HIGH FOREST ESTATES SUBDIVISION FILING NO. 1

A REPLAT OF LOT 1, BLOCK 7, WILLOW SPRINGS ESTATES

V2_Platt Drawings Comments.pdf Markup Summary

MINOR SUBDIVISION PLAT  
 HIGH FOREST ESTATES SUBDIVISION  
 FILING NO. 1

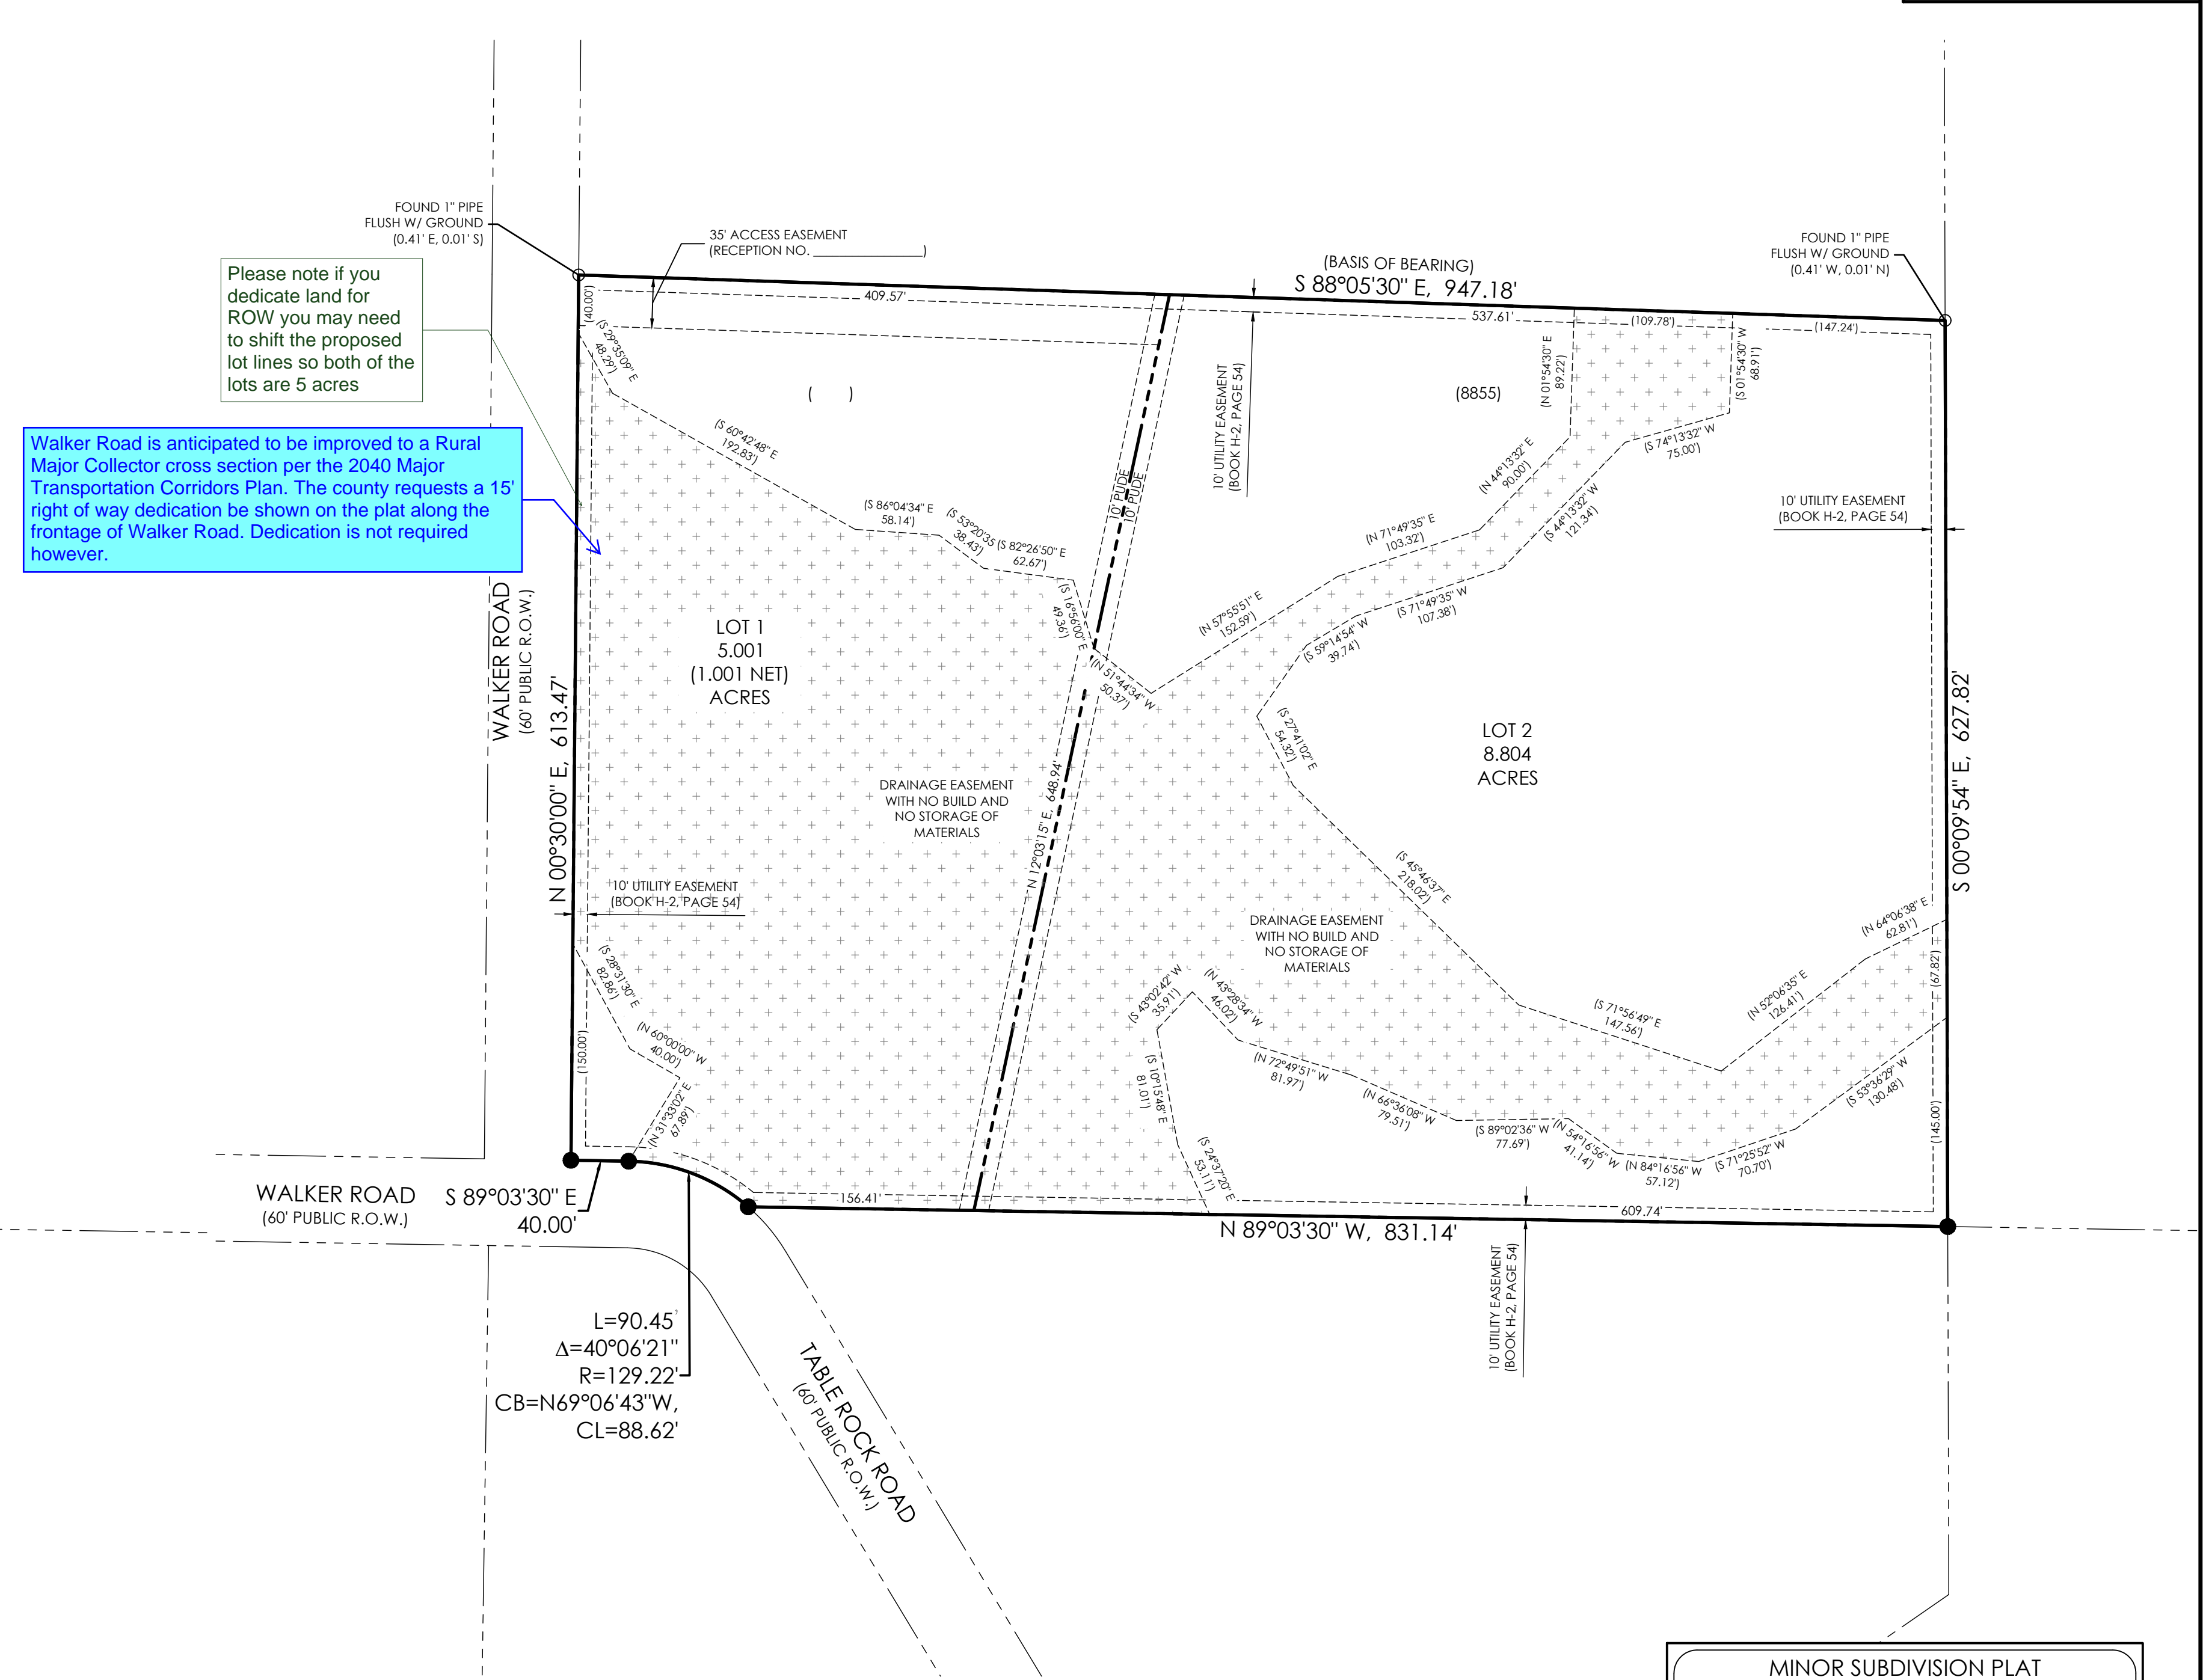
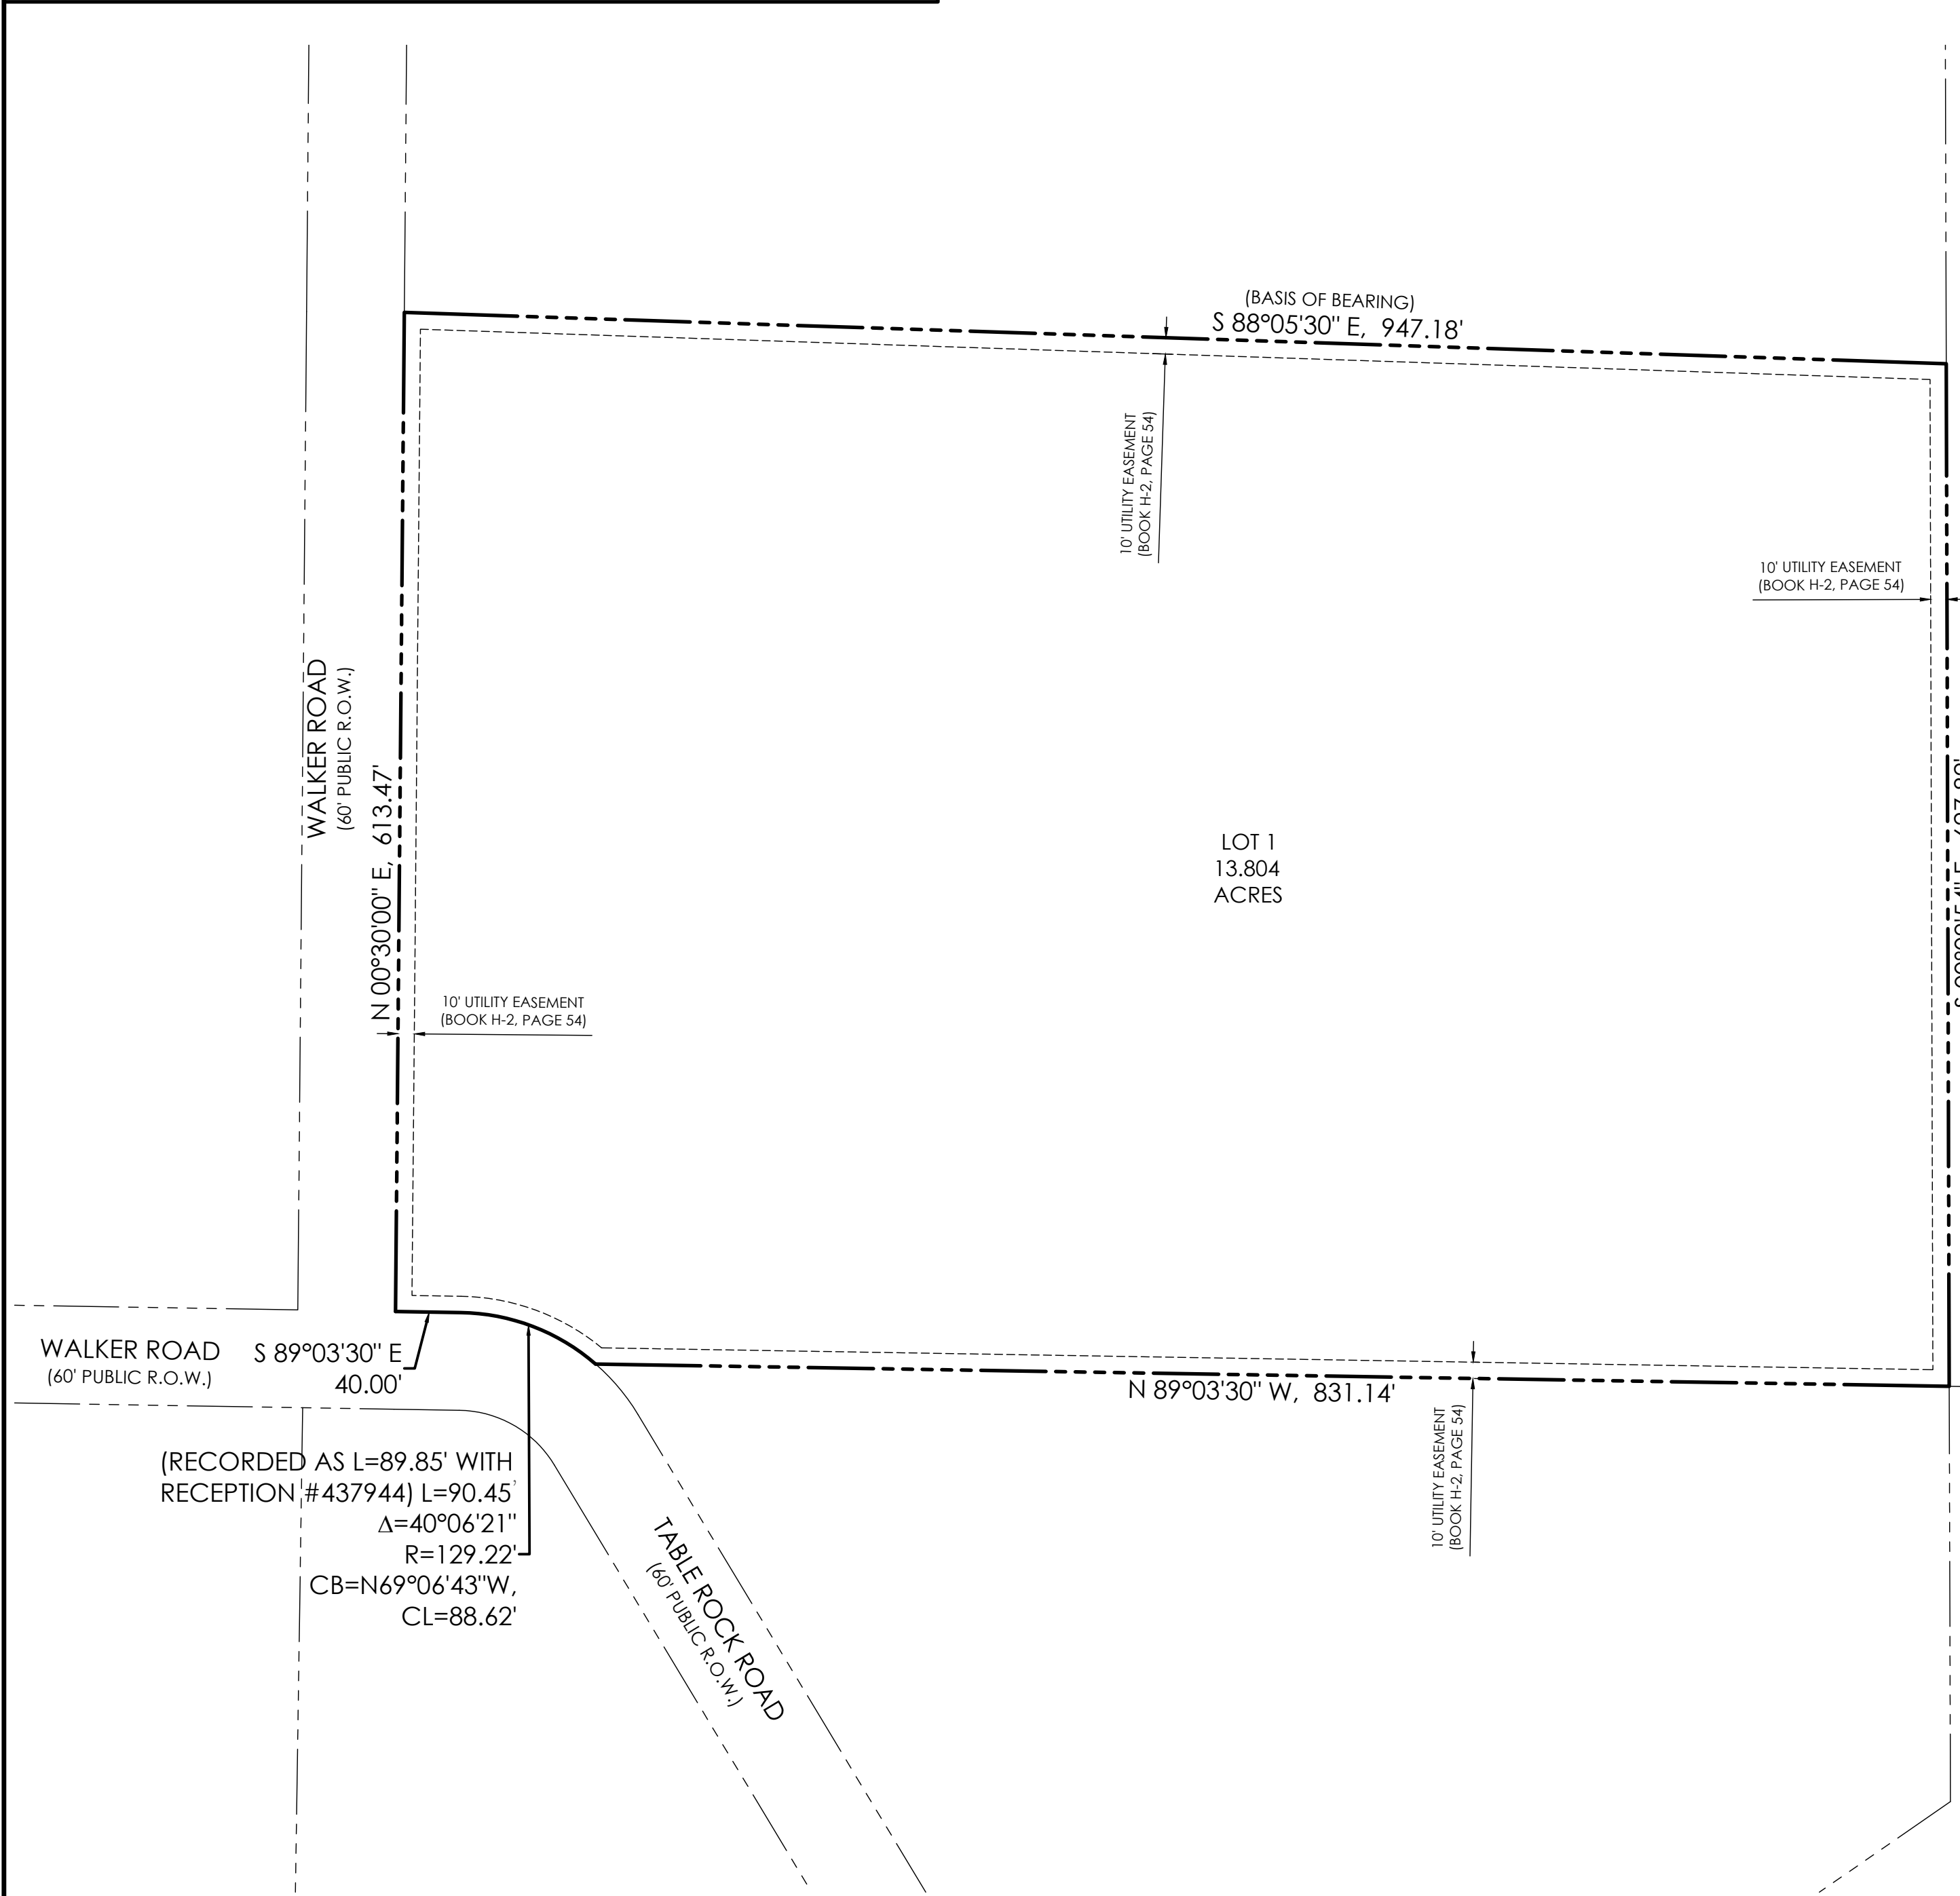
Subject: Callout
Page Label: [2] PLAT-PS
Author: Carlos
Date: 2/6/2024 11:34:07 AM
Color: ■

Please add "Public" to the name of the easement.

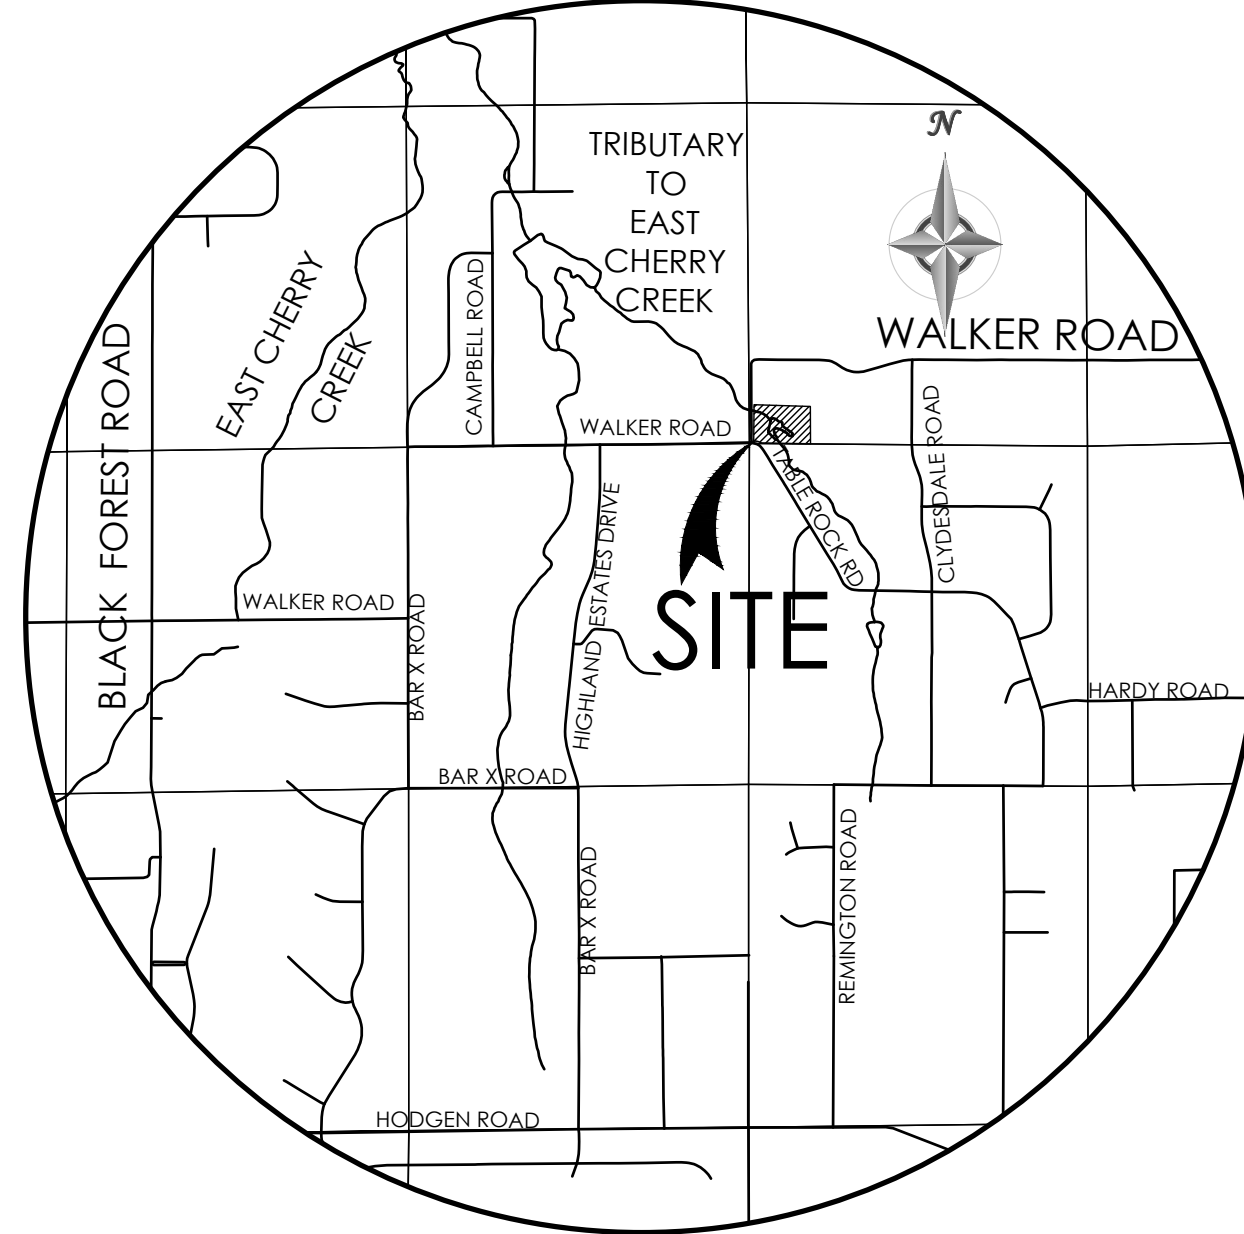
Subject: BoCC Replat
Page Label: [1] CS
Author: Ryan Howser
Date: 2/6/2024 1:30:18 PM
Color: ■

This should also include the second part for a replat:

Previous plat name in entirety is vacated and amended for the areas described by this replat subject to all covenants, conditions, and restrictions recorded against and appurtenant to the original plat recorded in the Office of the El Paso County Clerk and Recorder, Reception # _____.

Chair, Board of County Commissioners
Date
